From: O'Leary, Pat <OLEaryP@wsdot.wa.gov>
Sent: Thursday, October 24, 2013 7:45 AM
To: Jeff Watson; Christina Wollman; Brenda Larsen; Jan Ollivier
Subject: RE: SI-13-00002 Wesco
Attachments: SI-13-00002 Wesco Master File 10.8.2013.pdf

From: Jeff Watson [mailto:jeff.watson@co.kittitas.wa.us]
Sent: Tuesday, October 08, 2013 1:28 PM
To: Christina Wollman; Brenda Larsen; Ollivier, Jan; O'Leary, Pat
Subject: SI-13-00002 Wesco

PROPOSAL #1401  
WESCO INTERNATIONAL

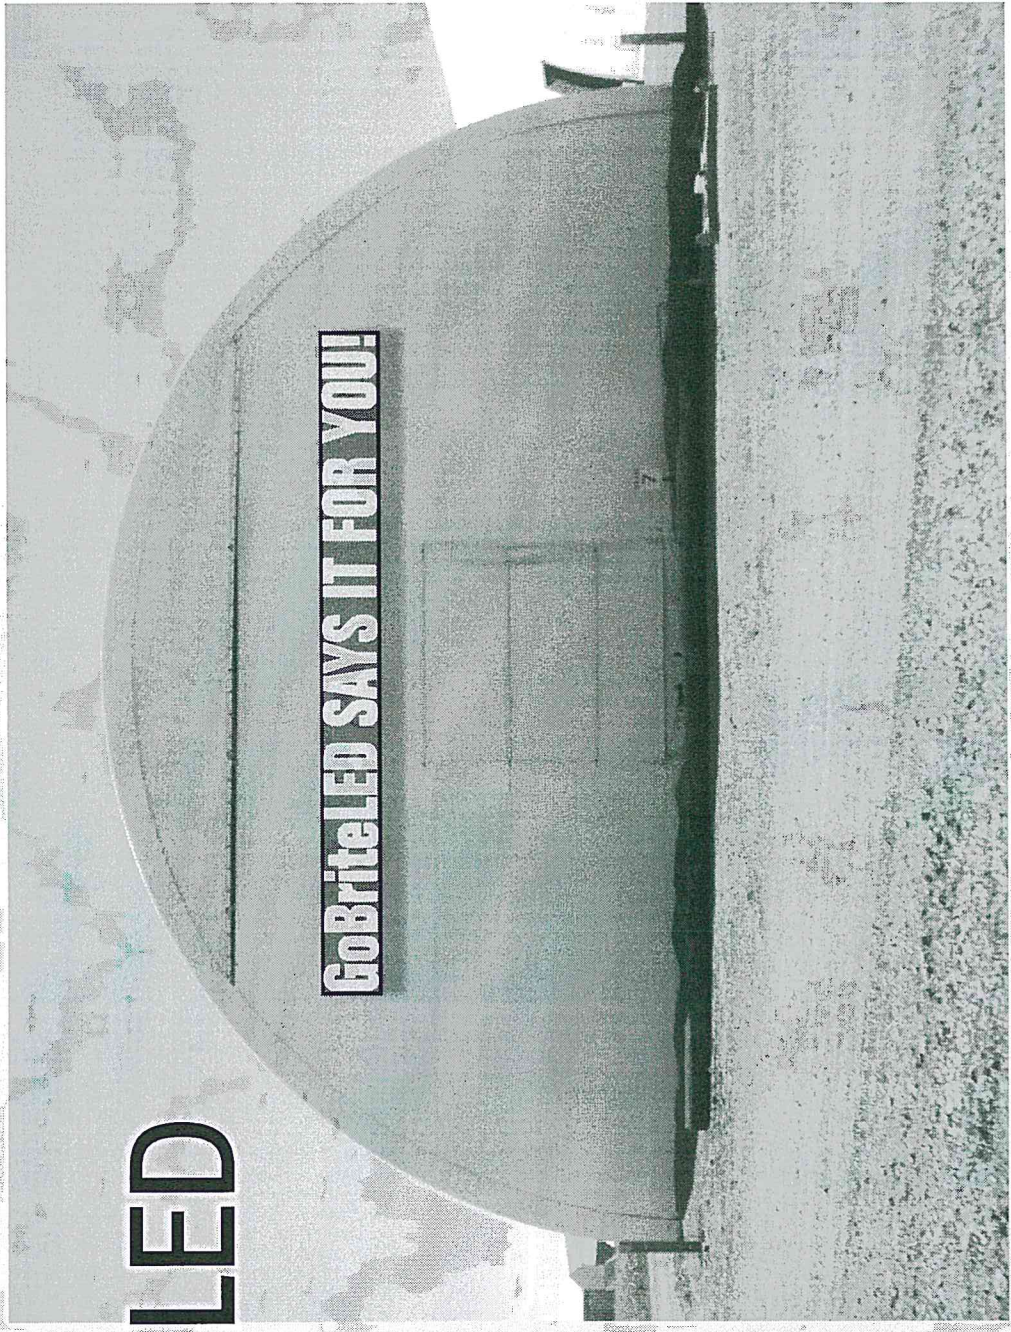
Now we've verified that the proposed sign is an electronic sign, here are rules for operating such signs as Type 3(a) on-premise signs visible to Interstate 90:

WAC 468-66-050(3)(g) Electronic signs may be used only as Type 3 on-premise signs and/or to present public service information, as follows:

- (i) Advertising messages on electronic signboards may contain words, phrases, sentences, symbols, trademarks, and logos. A single message or a message segment must have a static display time of at least two seconds after moving onto the signboard, with all segments of the total message to be displayed within ten seconds. A one-segment message may remain static on the signboard with no duration limit.

- (ii) Displays may travel horizontally or scroll vertically onto electronic signboards, but must hold in a static position for two seconds after completing the travel or scroll.

- (iii) Displays shall not appear to flash, undulate, or pulse, or portray explosions, fireworks, flashes of light, or blinking or chasing lights. Displays shall not appear to move toward or away from the viewer, expand or contract, bounce, rotate, spin, twist, or otherwise portray graphics or animation as it moves onto, is displayed on, or leaves the signboard.

- (iv) Electronic signs requiring more than four seconds to change from one single message display to another shall be turned off during the change interval.

- (v) No electronic sign lamp may be illuminated to a degree of brightness that is greater than necessary for adequate visibility. In no case may the brightness exceed 8,000 nits or equivalent candelas during daylight hours, or 1,000 nits or equivalent candelas between dusk and dawn. Signs found to be too bright shall be adjusted as directed by the department.

The intent of this regulation is to mitigate driver distraction. The most common violations we see on electronic signs are flashing and overboard use of graphics (spinning, pulsing, appearing to move toward/away, etc.). Advice here is to keep it simple; display the message for minimum two seconds, display next message, and so on.
